**BCA ASSESSMENT REPORT -
SCHEMATIC DESIGN**

**PROJECT: Goulburn Hospital & Health
Services Redevelopment**

PREPARED FOR: TSA Management

Date: 27 September 2017

DESCRIPTION
PROPOSED PRECINCT
PLAN - THIRD FLOOR

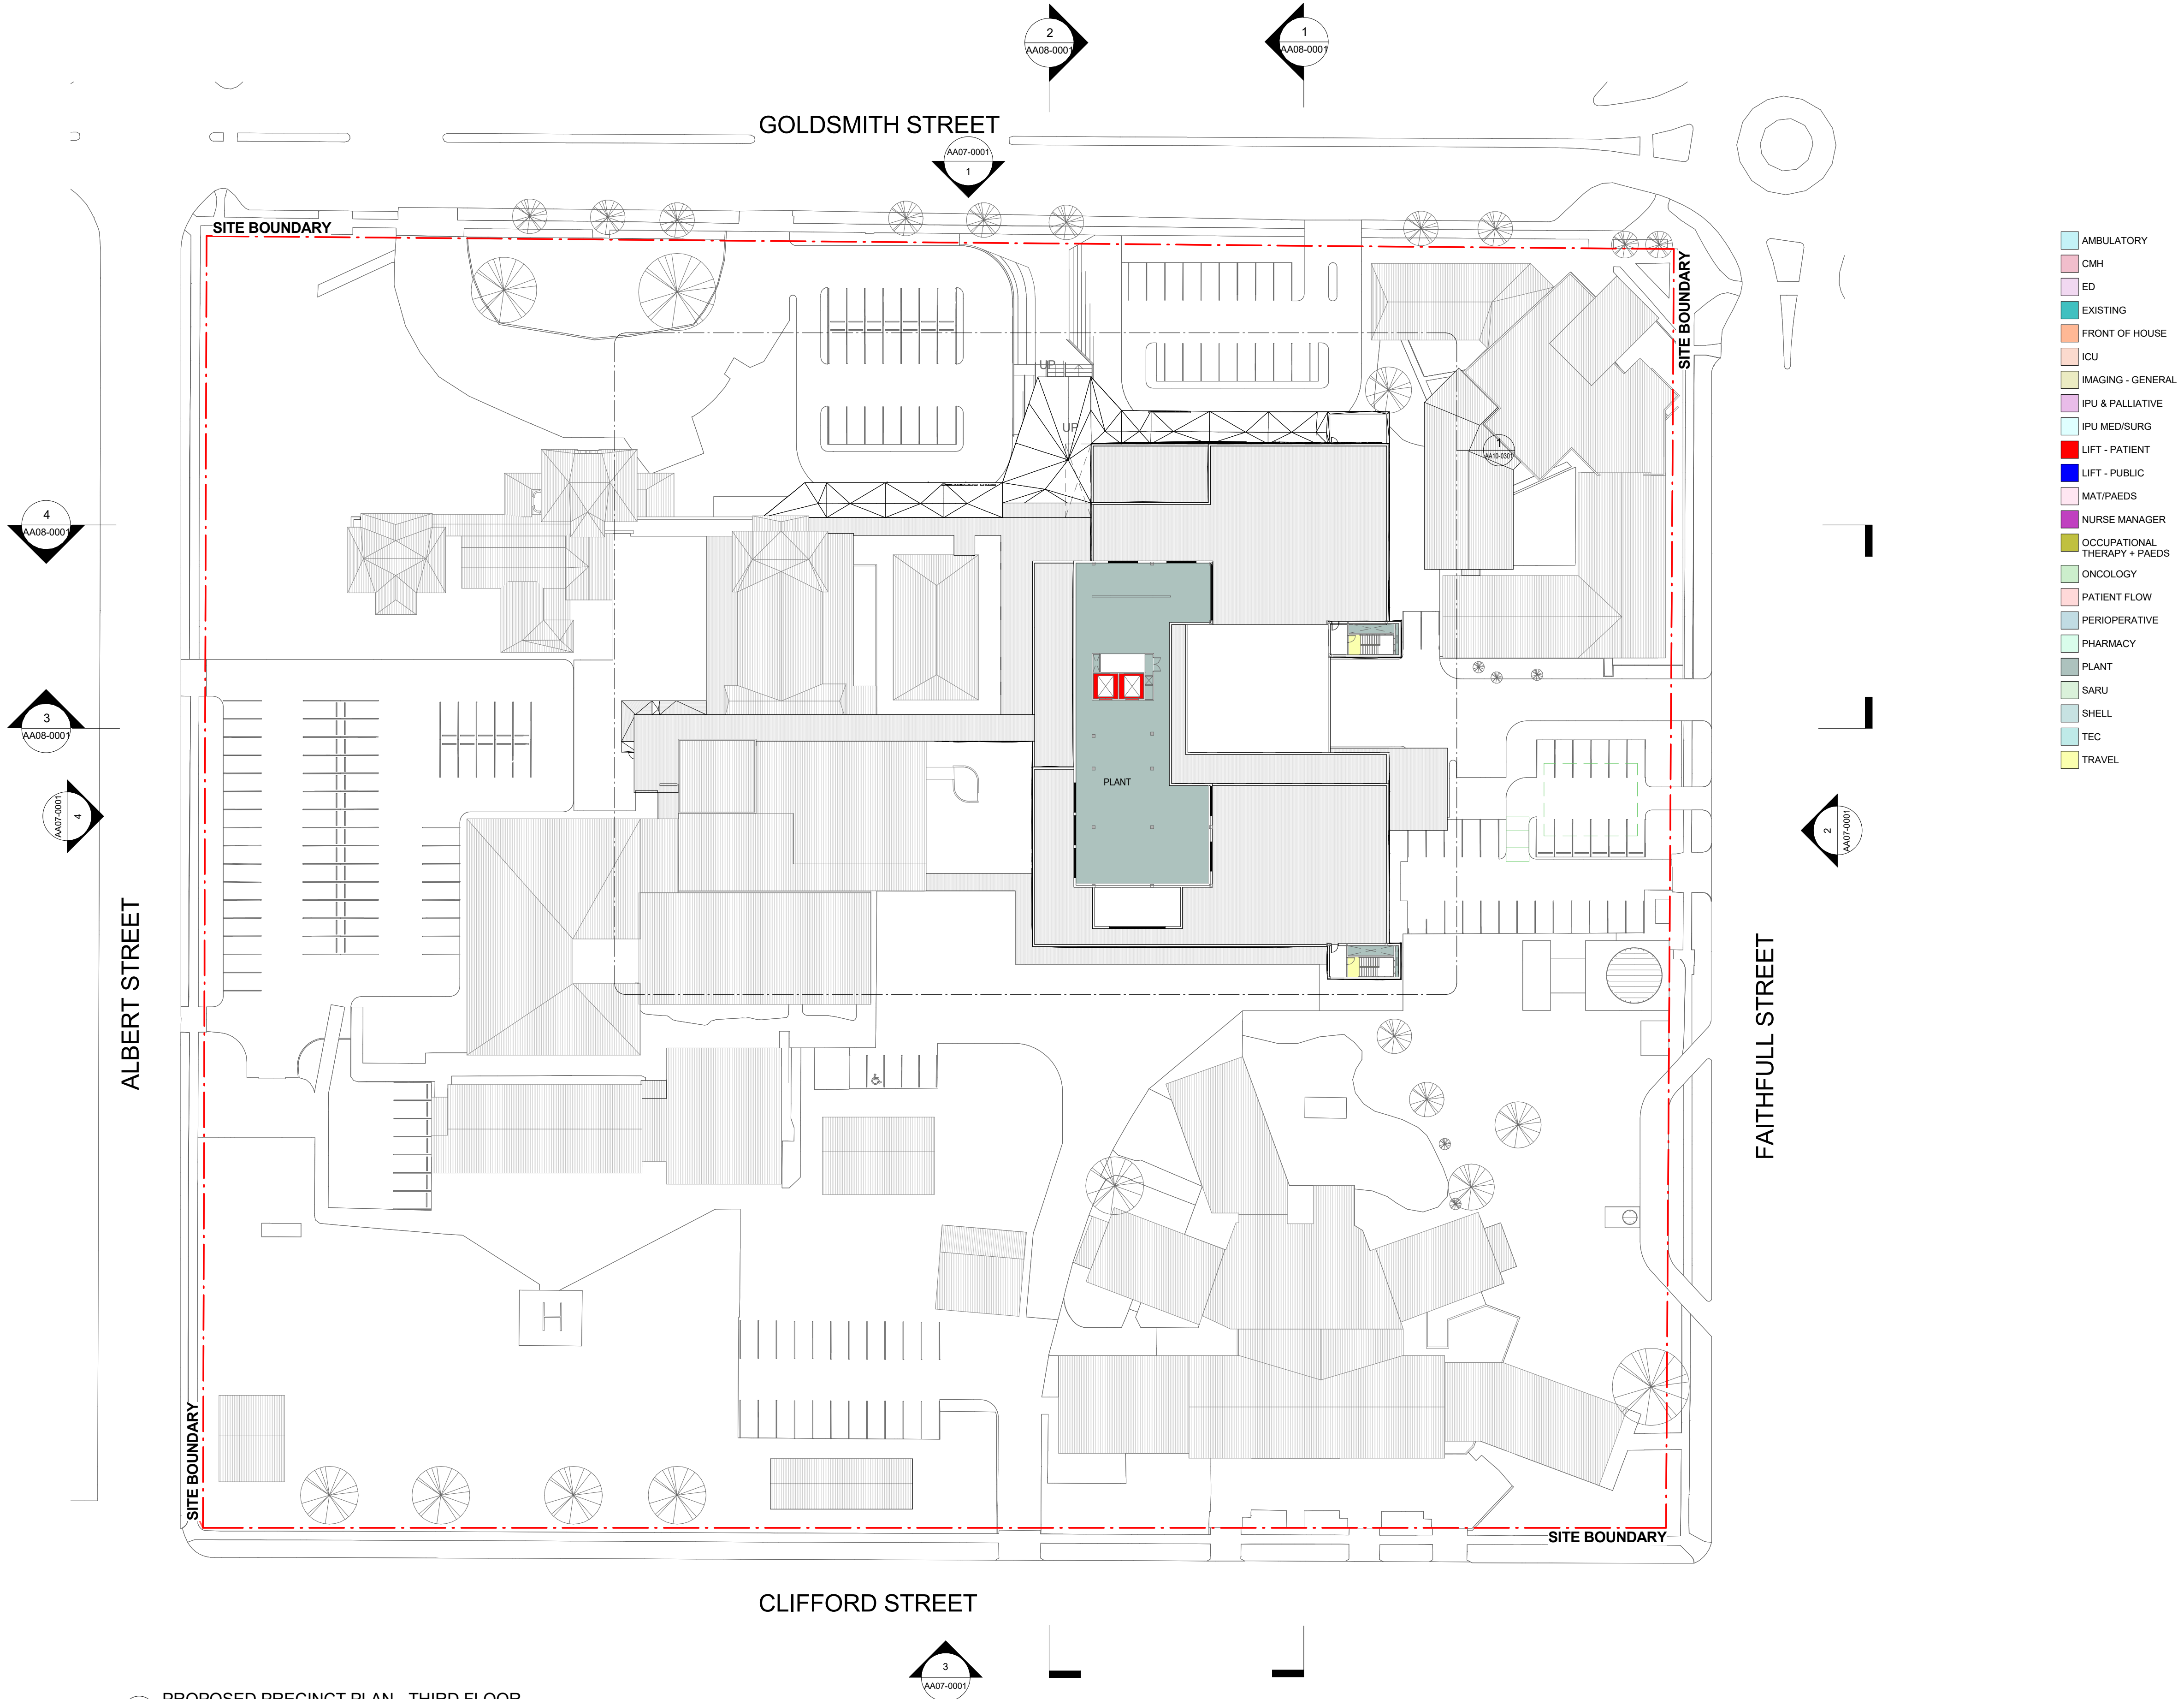
5.	D1.2	The central Plant room on Level 3 requires access to the fire stairs. An additional exit to open space is required to southern side lower ground floor medical imaging. An additional doorway is required from the MRI scanning room on lower ground, to provide access to point of choice. Confirmation required if egress for pathology is provided by stairway. The new link is “enclosing” the existing pathology building therefore egress from this building must be considered.

10.	D1.7	Level 3 plant rooms open directly into fire stair without an airlock, or lobby.
11.	D1.1	Discharge of horizontal exits into fire compartments without an egress stairway or direct to open space occurs at level 1 and 2. The required clear space on the egress side of the fire wall will also be assessed in the fire engineering report.
